An
Coimisiún
Pleanála

Inspector's Report ACP-322967-25

Whether the use of Hayden's Hotel to provide accommodation for displaced persons or individuals seeking international protection, constitutes exempted development or does not constitute exempt development

Dunlo Street, Townparks, Ballinasloe, Co.Galway

Figure 9.0 Southwest elevation with 5 no. proposed windows, as submitted at Application Stage.

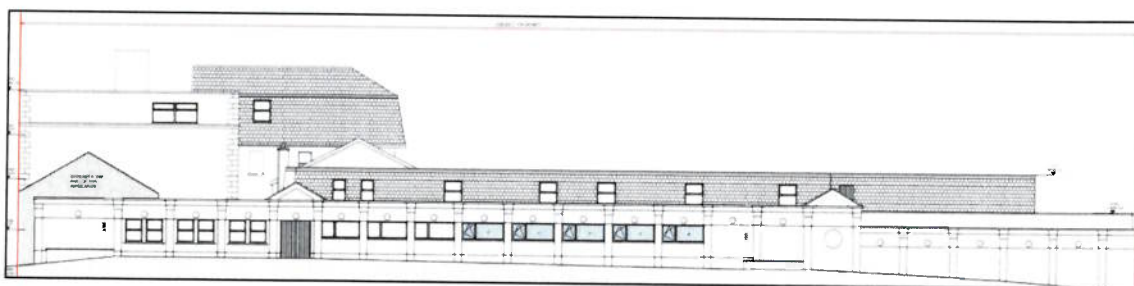
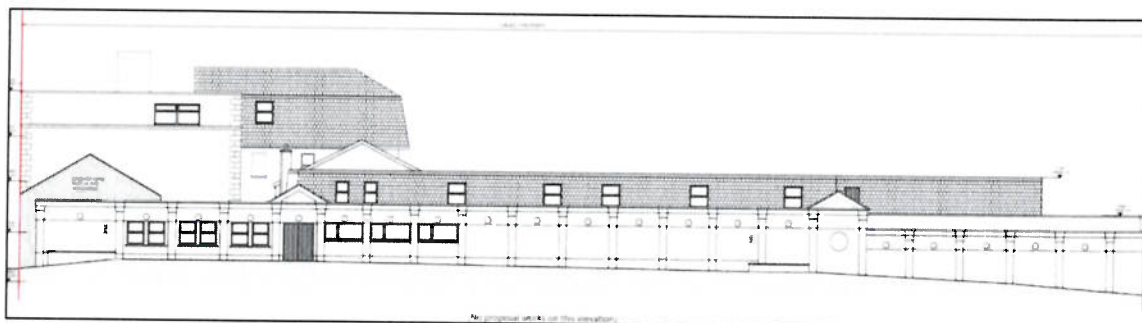
9.2.13. I note that the PA's Section 5 Declaration states that the addition of 9 no. bedrooms and 5 no. windows on the ground floor along with the extensive refurbishment works, which are required to make the hotel habitable, will require the benefit of planning permission.

- 9.2.14. I would note that these 5 no. windows are included on the submitted elevations drawing (drawing no. 2024.159.S5.300) received by the PA on the 7th of March 2025. However, the subsequent elevation drawings, received by the PA on the 4th of June 2025 in response to an additional information request, illustrate that these same 5 no. windows are omitted from the proposal.

- 9.2.15. The single proposed alteration to the external elevation is the replacement of a door opening with a window on the rear elevation facing onto Jubilee Street.
